Proposed Barn Plans and Elevations

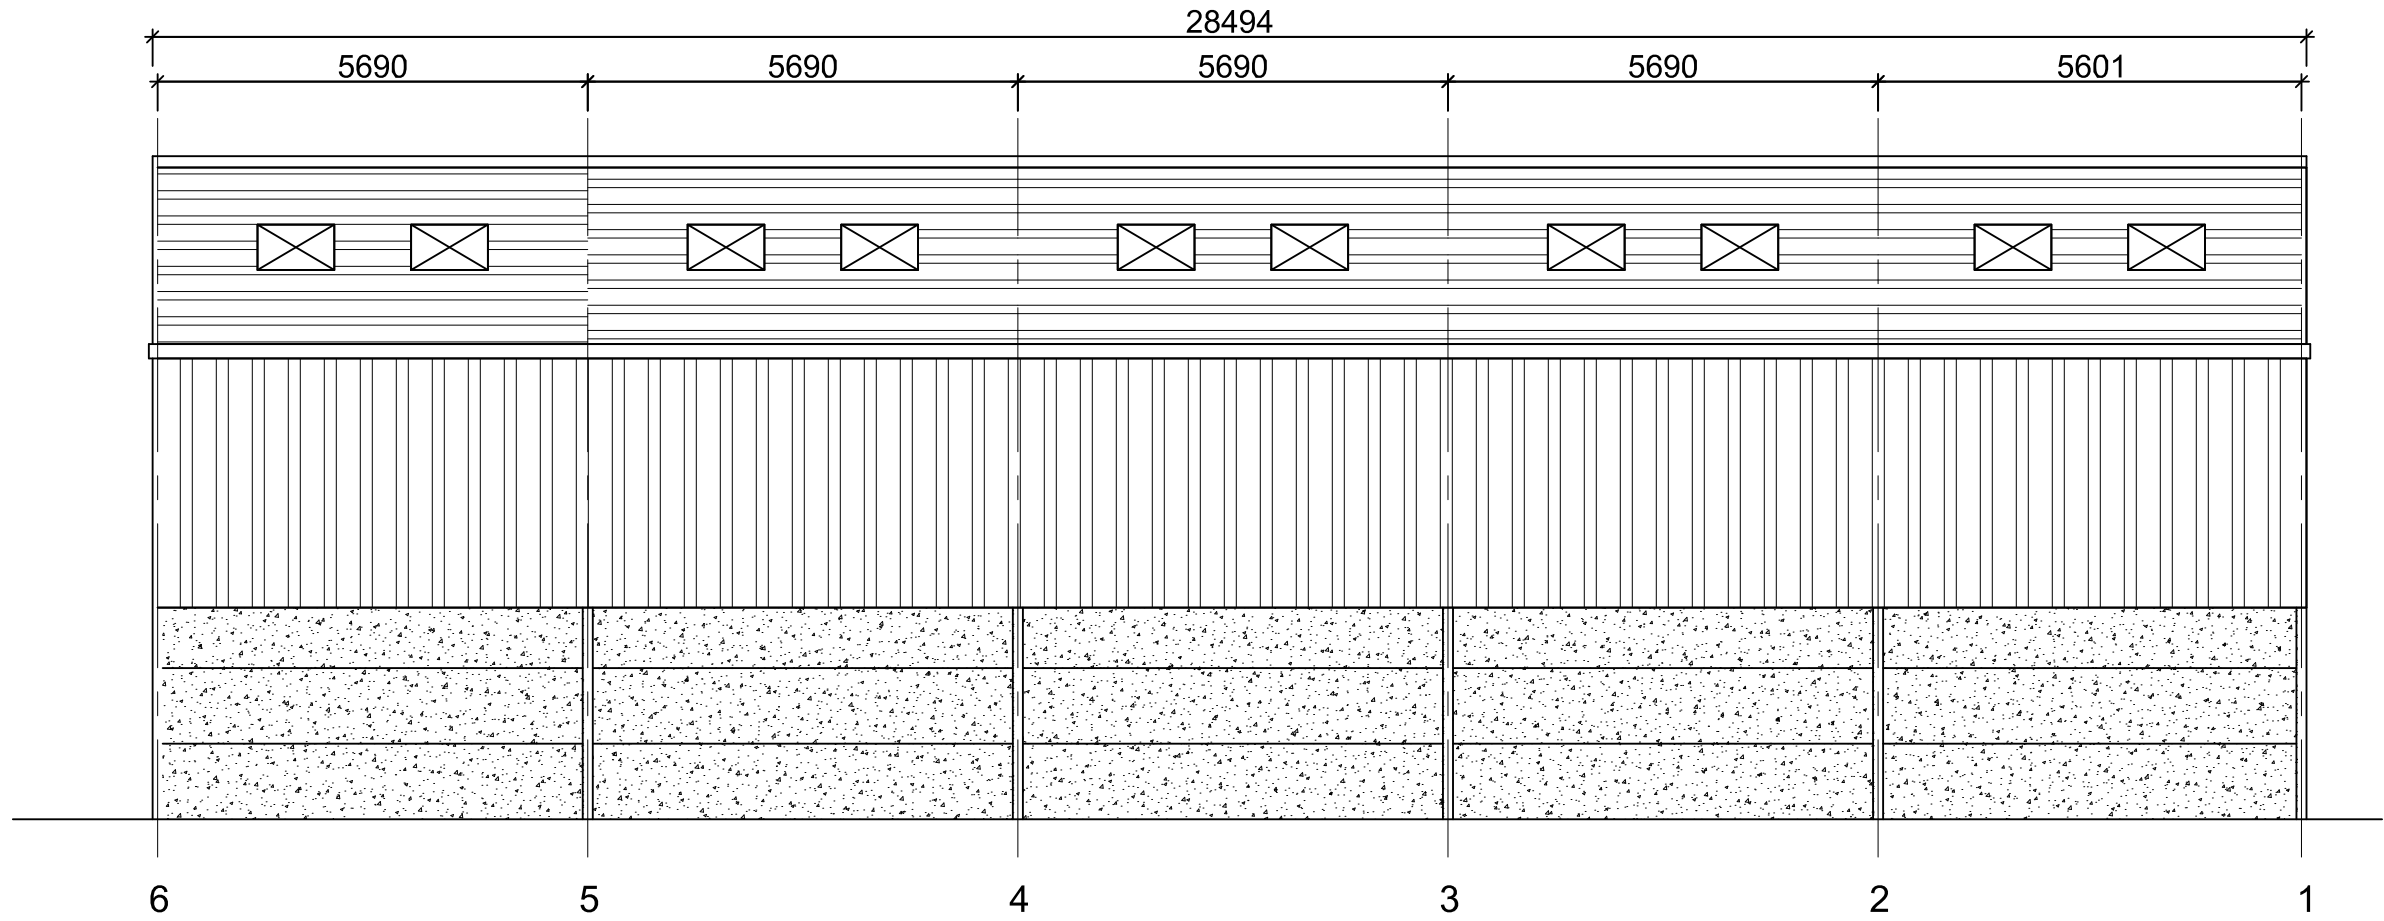
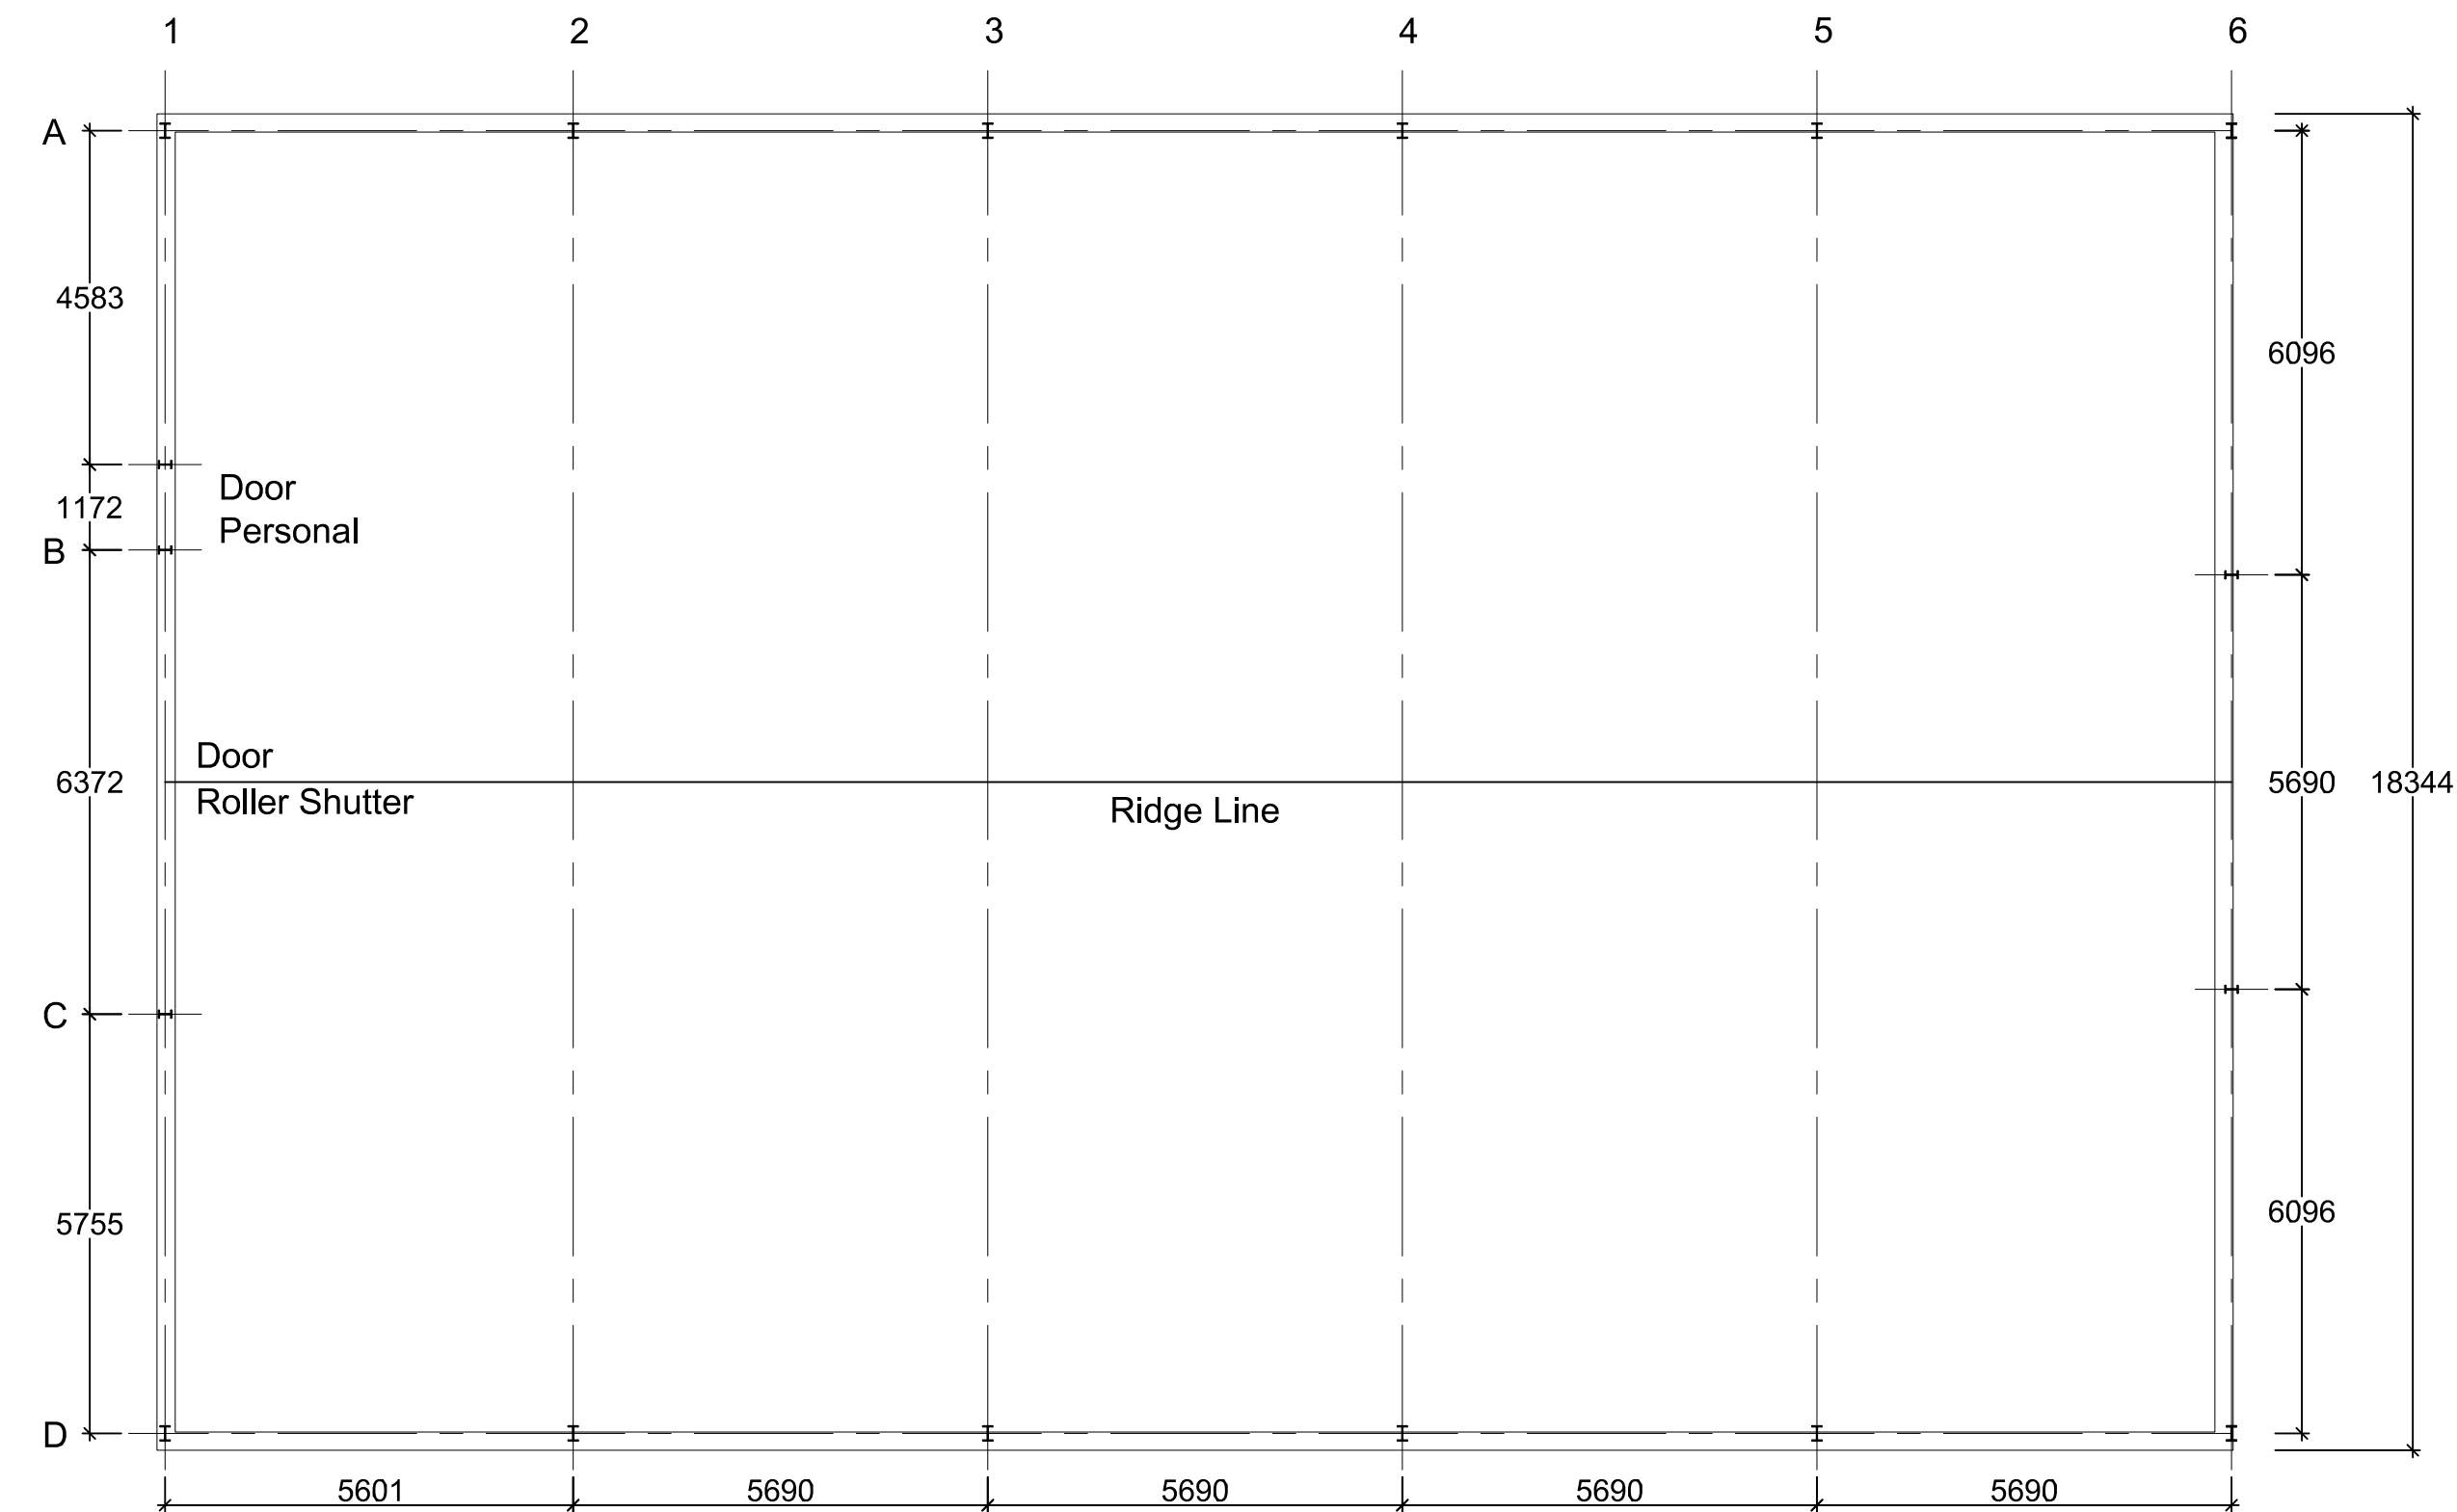
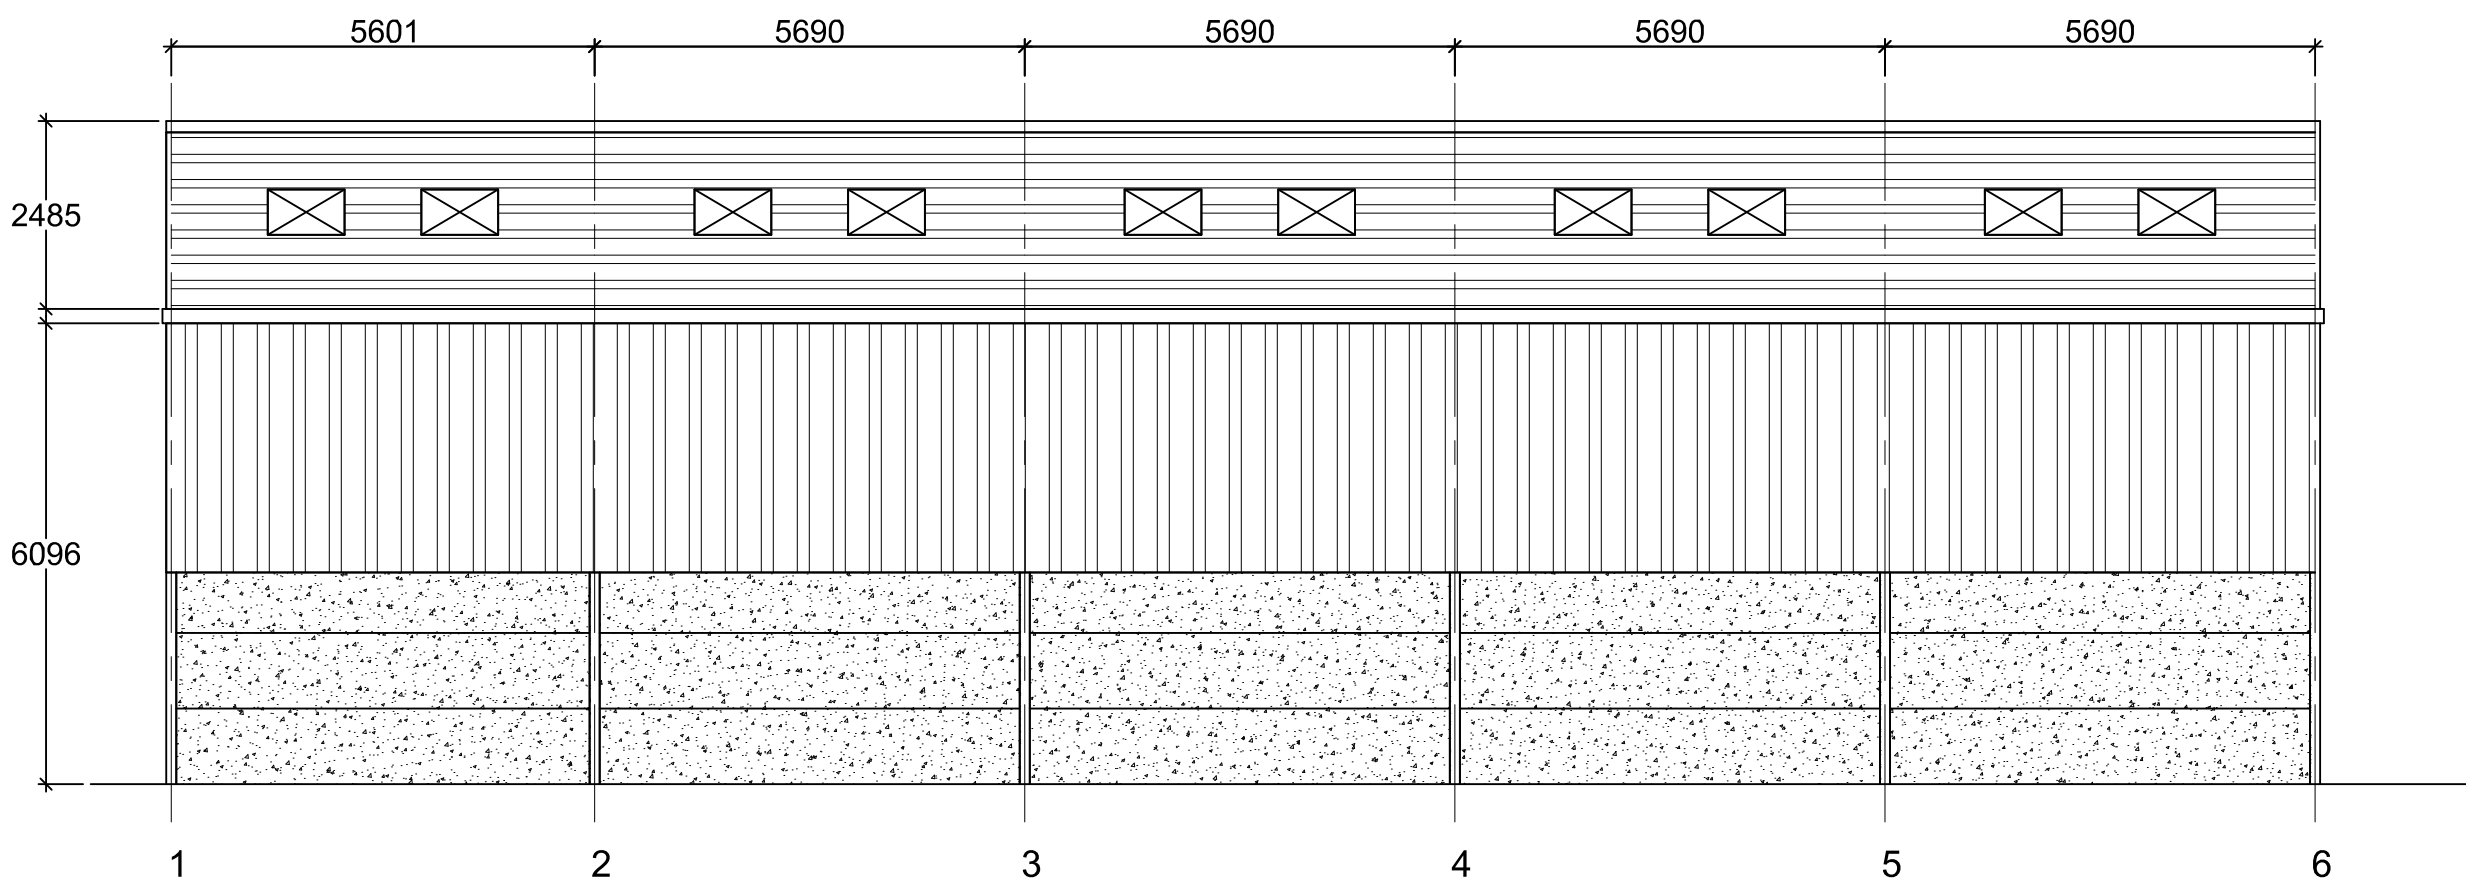
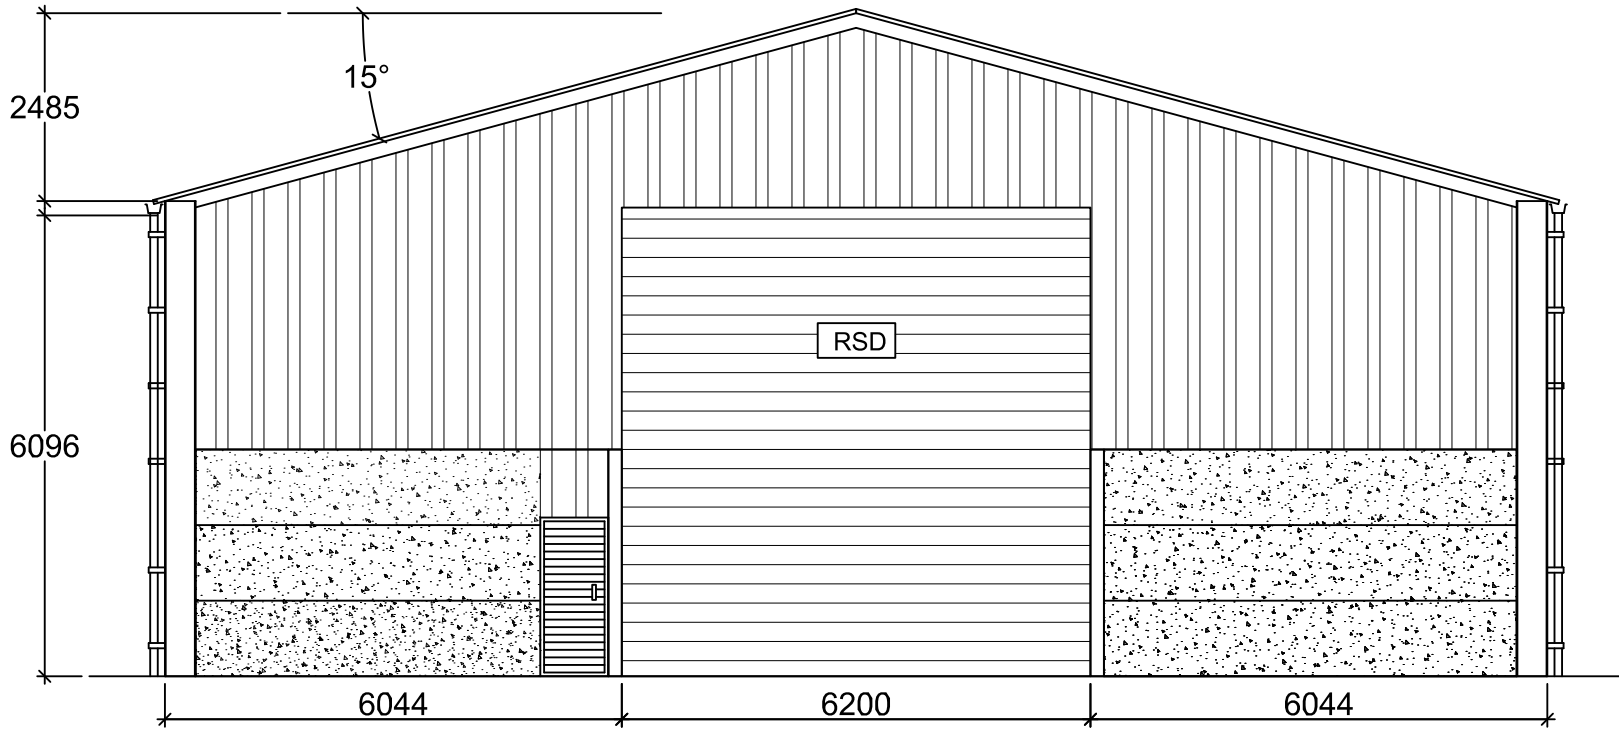
Please can you let me have a revised site plan and elevation plan indicating native tree planting along the southern boundary as discussed, by Wednesday next week?

Is there no option to reduce the width/length of the building slightly so that tree planting can be included within the red edge? Or to move the building forward or sideways within the red edge? A reduction in size would help to address our concerns and those of the Parish.

I have reconsulted the Ecologist based on the details submitted and await her response. In the meantime I would appreciate receipt of a revised site plan indicating the provision of native planting along the south elevation of the barn.
